DECISION DELEGATED TO HEAD OF PLANNING

Application No: H03-0094-25 **Applicant:** Mr & Mrs Perkins
Proposal: Single Storey Front Extension
Location: 1 Brownhill Farm Campains Lane Deeping St Nicholas
Terminal Date: 14th May 2025

CASE OFFICER ASSESSMENT

Proposed Block Plan 1:500

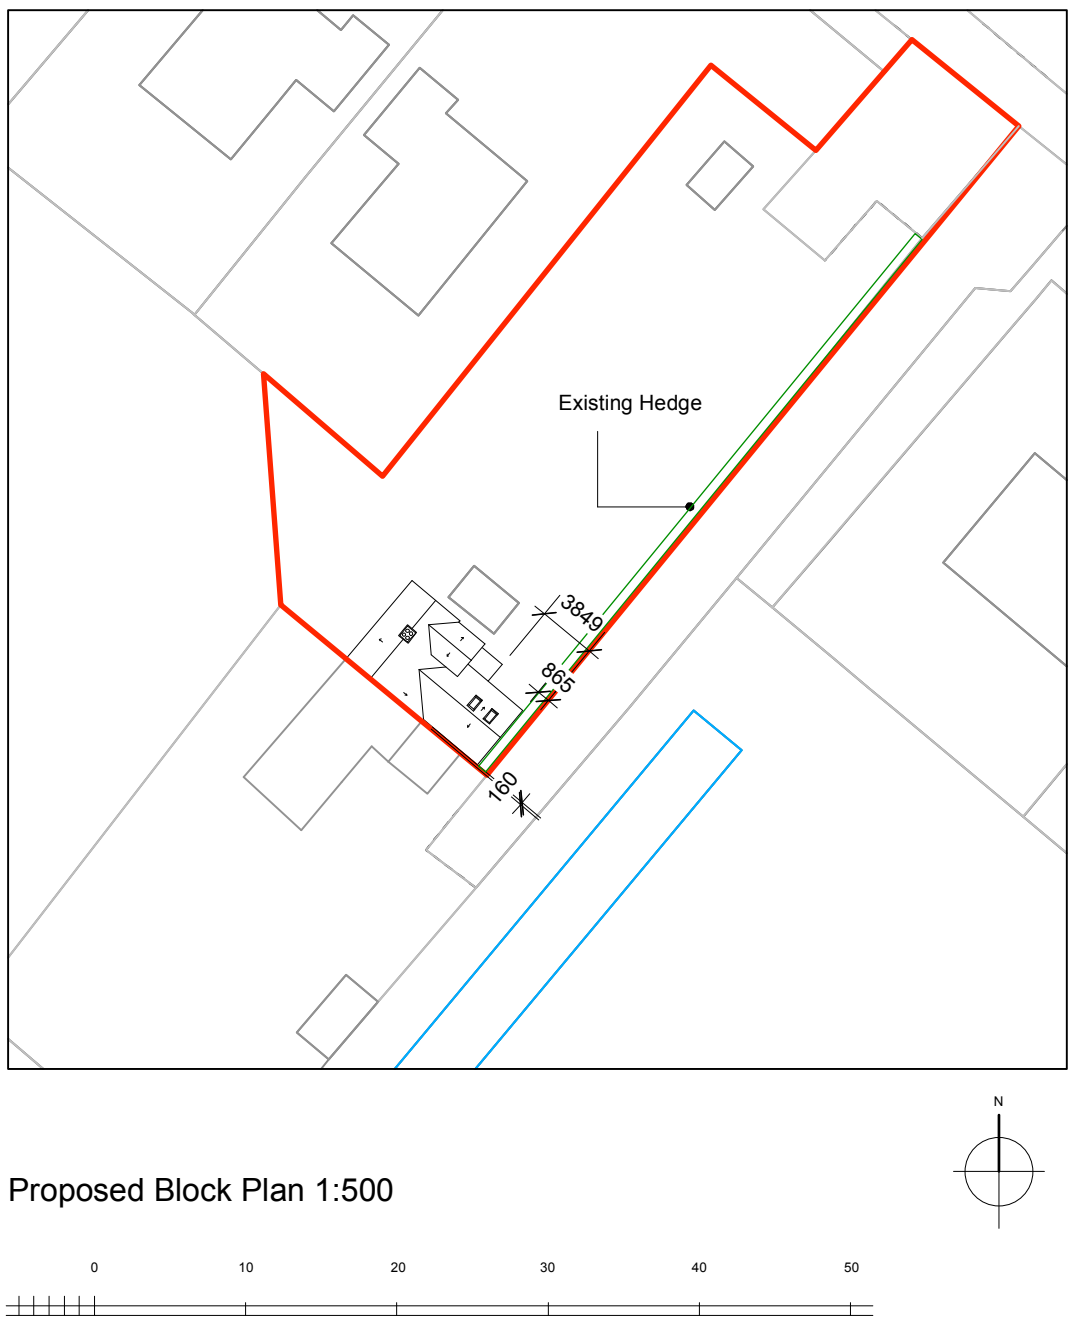
"Existing and proposed block plan needs to show parking."

The proposal would have no impact upon highway safety or parking. While the comments of the Highway Authority are noted here, as the access and parking are not being altered, there is no need to redemonstrate them.
